JPPC ref: AC/6909
Portal Ref: PP- PP-12478341

22nd September 2023

**17/02419/FUL (AS VARIED BY S73 APPROVAL 23/00099/VAR) –
ERECTION OF NEW MUSIC SCHOOL, CONSTRUCTION OF LINK TO
LYNAM HALL, LANDSCAPING INCLUDING THE FORMATION OF A
NEW COURTYARD, GARDEN AREA TO LANE HOUSE AND
ENTRANCE COURTYARD. VARIATION OF CONDITIONS 2, 4 AND 8
TO ALLOW CHANGES TO LANDSCAPING DETAILS
AT DRAGON SCHOOL, BARDWELL ROAD, OXFORD OX2 6SS**

DRAWING TITLE  
Fire Exit To Main Recital Hall

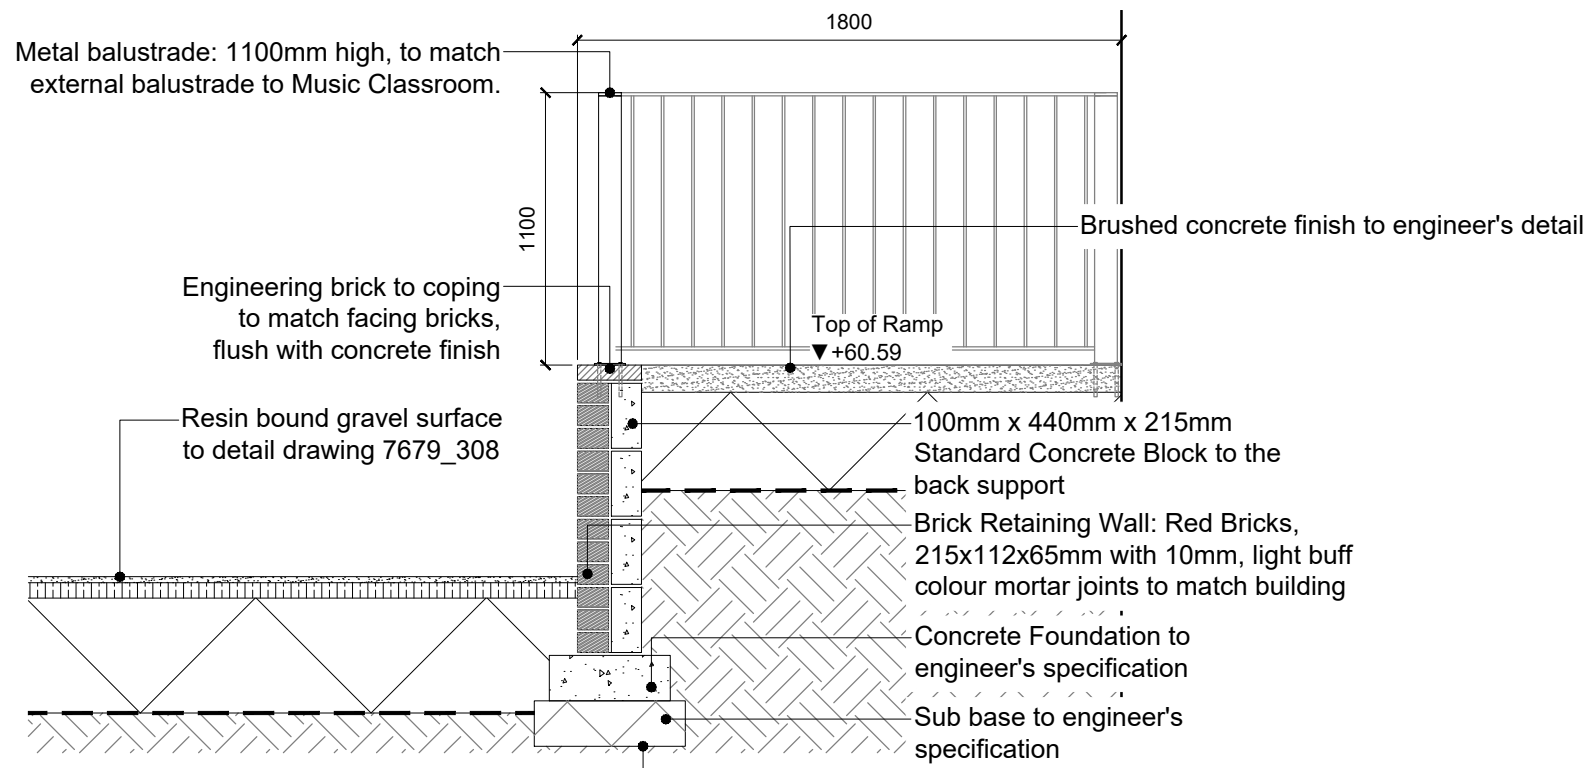
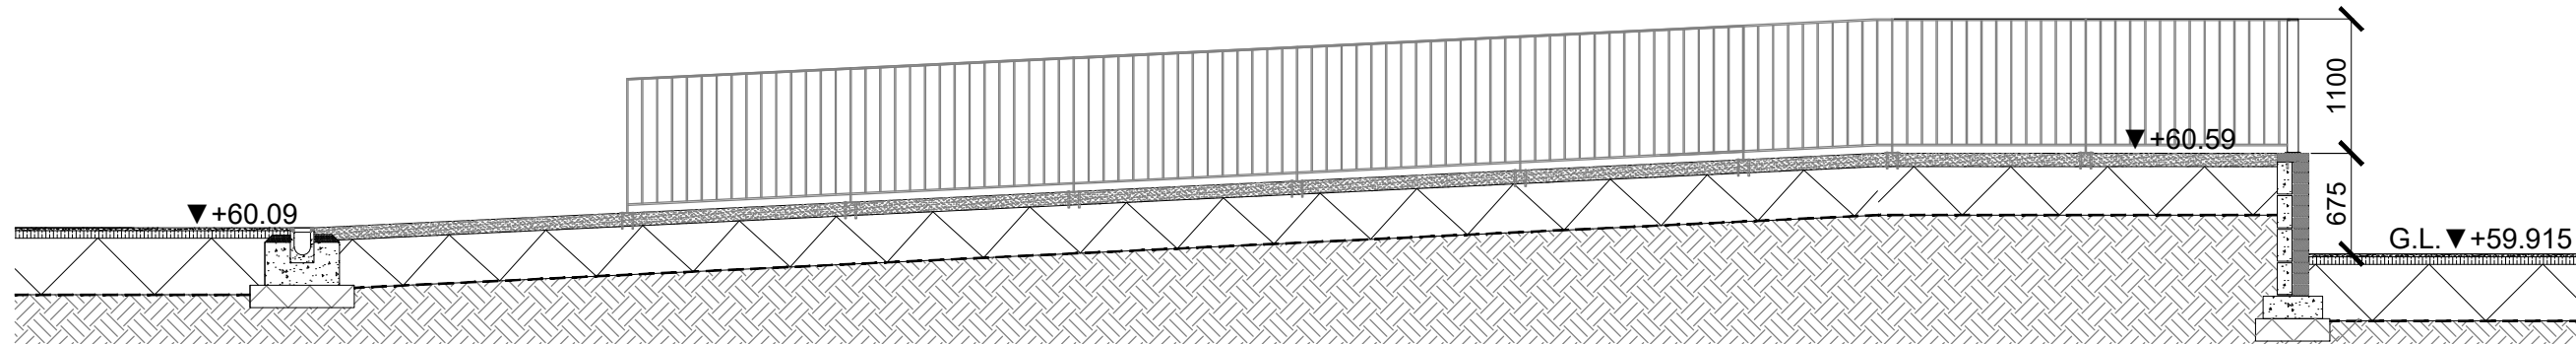
Changes to the internal arrangement and egress strategy for the main recital hall are proposed as a result of building control comments on the unsuitability of the previous strategy, which allowed for an internal muster point for reduced mobility occupants. The revised fire evacuation strategy has all occupants of the main recital room evacuating via a newly implemented fire door facing north-north-west, with steps and a ramp to mitigate accessibility issues as a result of the level changes. The resulting impact is that the east-facing fire exit is surplus to requirement, and thus omitted. In order to better coordinate the internal arrangement, the steps down the fire exit lobby are replaced with a panel of fire rated glazing.

DRAWING TITLE  
**Planter with Seat Edge**

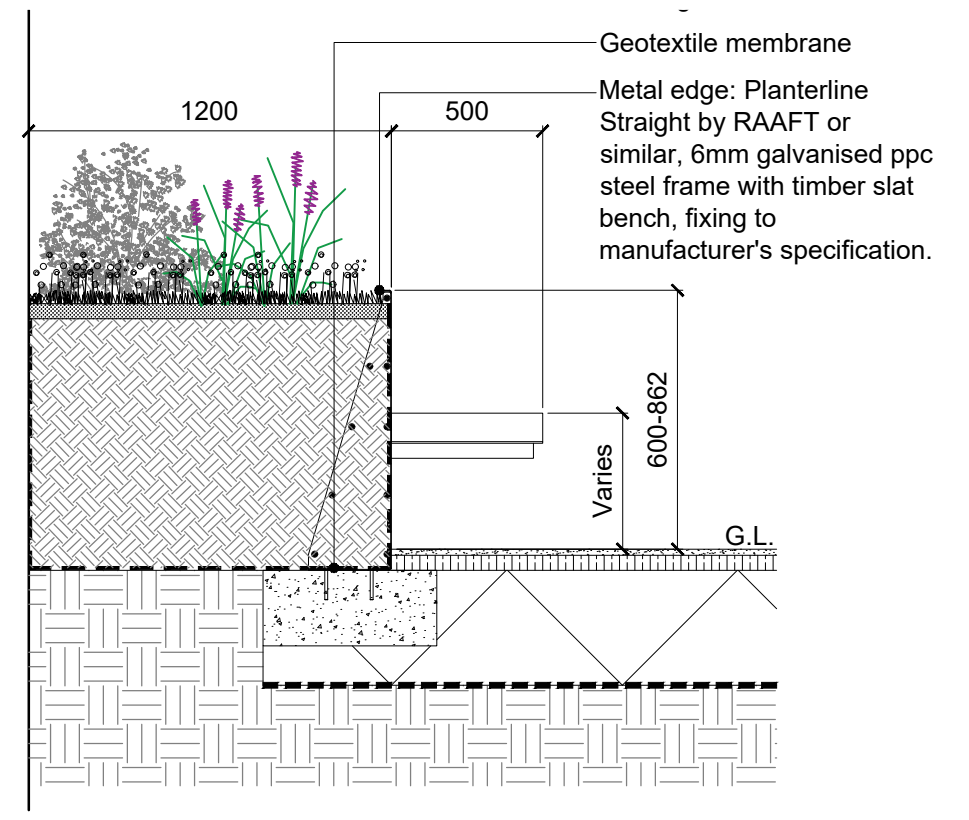
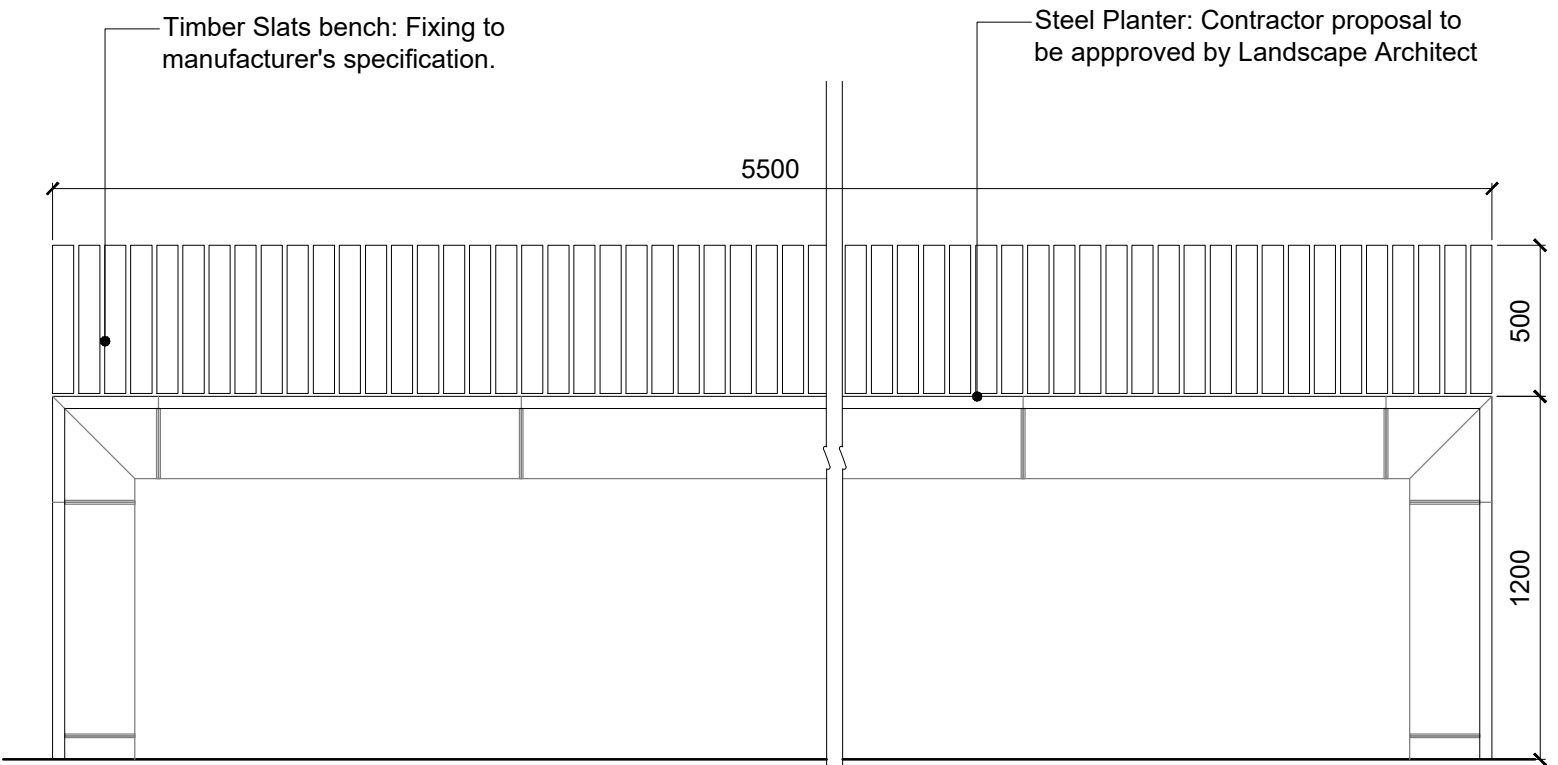
The inclusion of steps and a ramp out of the recital room require the re-coordination of planters between the new music facility and the existing Lynam Hall, in order to maintain evacuation walk-way widths, as per building control regulations.
